## STAFF REPORT

### SUNCADIA PHASE 2 DIVISION 6 (LP-20-00004)

TO: Kittitas County Board of County Commissioners  
FROM: Jeremy Johnston, Planning Official  
RE: Suncadia Division Phase 2 Division 6 Preliminary Plat (LP-20-00004)  
DATE: March 16, 2021 [Hearing Date]

### Roadway Sections

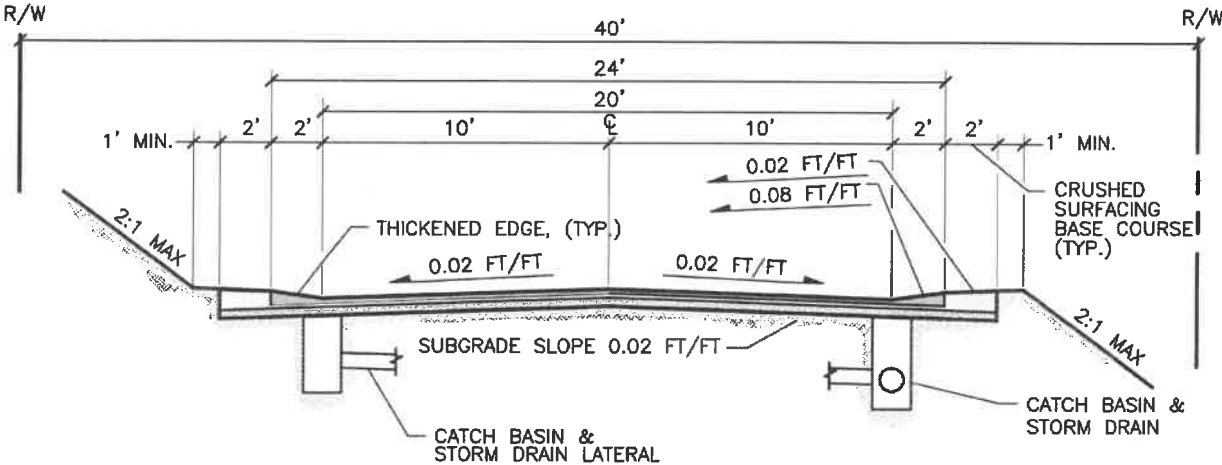
6. Please submit construction drawings including a profile of the road with labeled geometry, typical cross sections, horizontal geometry labels, and labeled utilities as described in section 5.1(h)(2) of the Suncadia Development Agreement.

Staff Response: Applicant provided a response to PW comments, included as Index #32 of the Master File. The applicant will adhere to all applicable regulations as outlined in the Development Agreement. Revised preliminary plat drawings were submitted and included as Index #35. The revised drawings in conjunction with conditions outlined in this staff report address the issues presented by KC Public Works. The applicant also provided an update on the sewer and water connection count for the MPR (See Index # 37)

NEW SUNCADIA, LLC
SUNCADIA PH 2-DIV 6 (NELSON RIDGE)
 CONCEPTUAL UTILITY PLAN
 WASHINGTON
 KITTITAS COUNTY

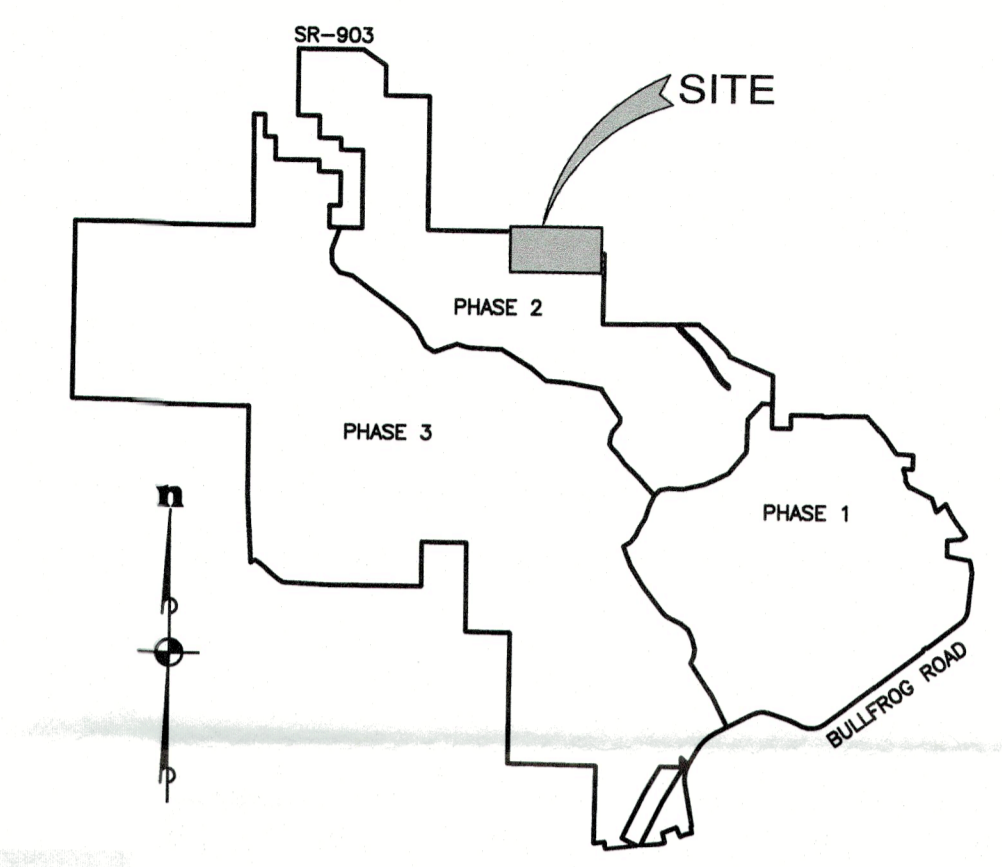
7. Please submit documentation verifying stormwater runoff in this division is consistent with the Master Drainage Plan for the site.
8. Please submit documentation verifying there is sufficient capacity in the existing wastewater collection system to handle this new division.

9. In addition to the letter from the Suncadia Water Company, please provide an inventory of equivalent residential units, or the accounting method utilized in the general sewer plan, affirming sufficient capacity serving the plat.
